Our ref: Q210454
Your ref: BC080001
Email: [REDACTED]@quod.com
Date: 4 August 2021

Application by London Resort Company Holdings for an Order Granting Development Consent for the London Resort

Clarifications and Additional Assessment Information Requests

2029 Gate Two Opening
 Traffic Flow Diagram
 AM Peak 08:00 - 09:00

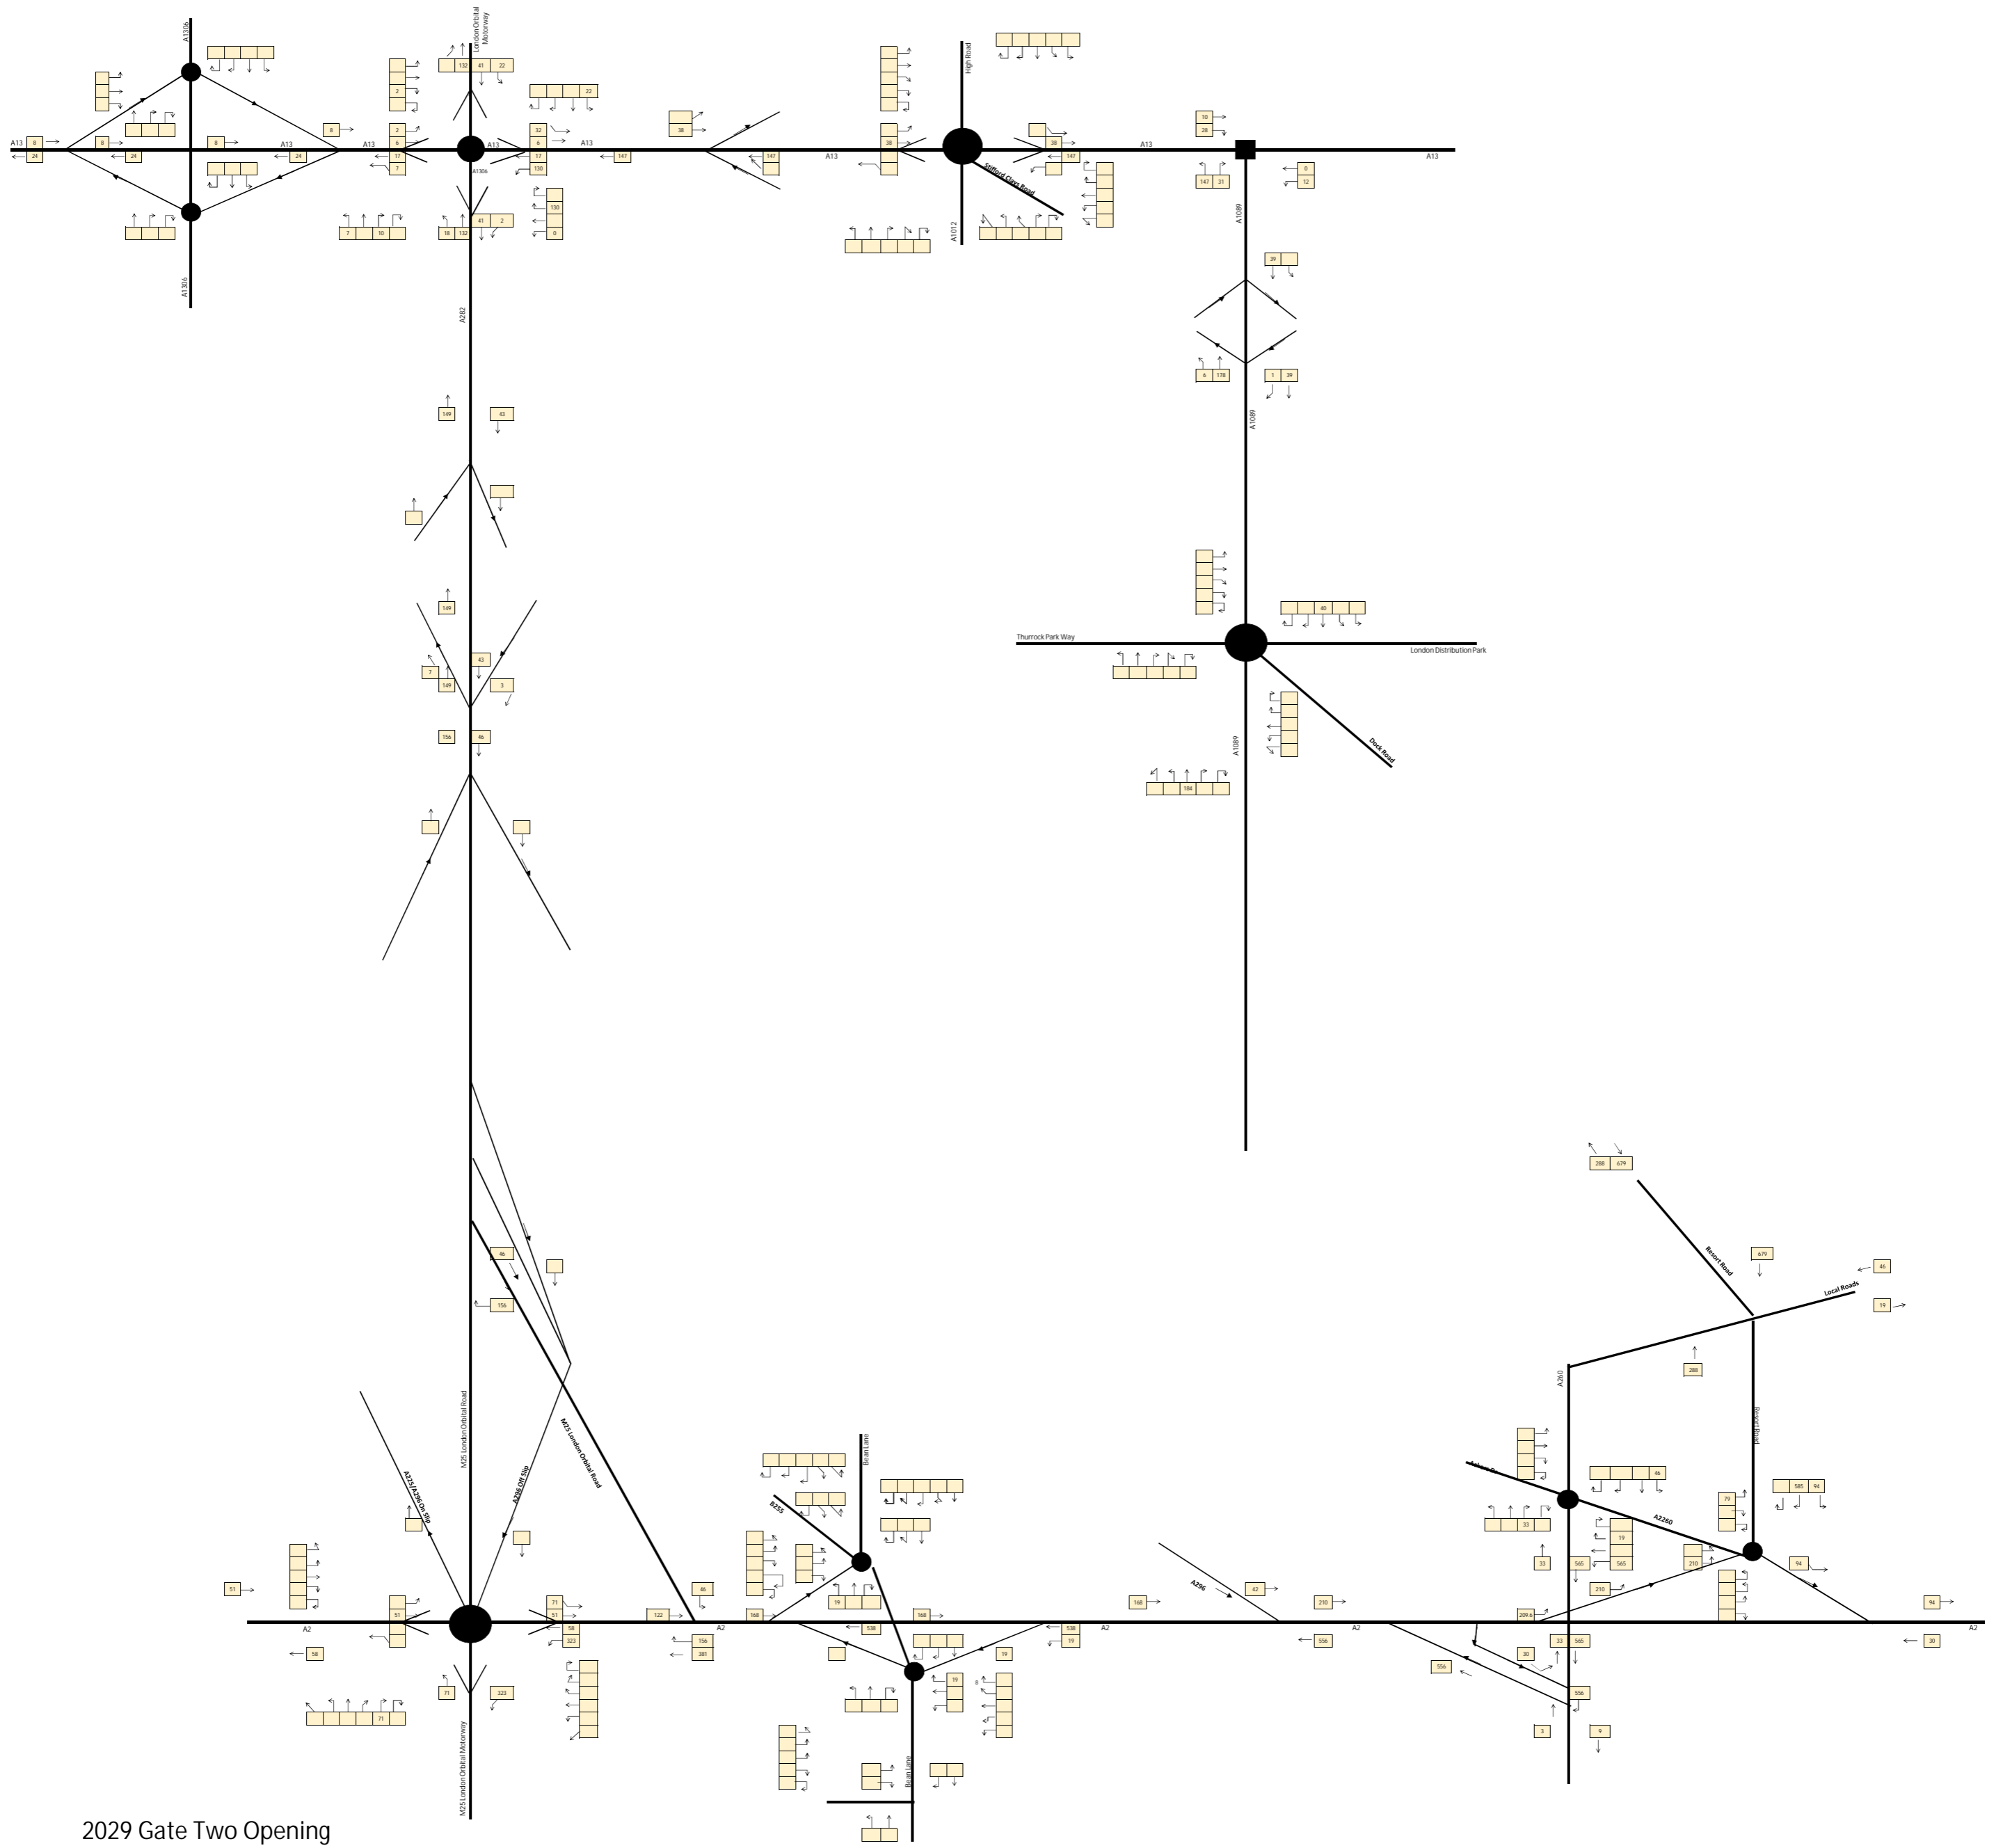
7.	The traffic flow diagrams in Appendix TA-R of the Transport Assessment (APP-116 6.2.9.1 ES Ap 9.1) do not show where traffic routed east on the A2 travels to. This is a significant concern and further modelling is required to enable the Authorities to assess the impact on the network and ensure appropriate mitigation is secured.		✓
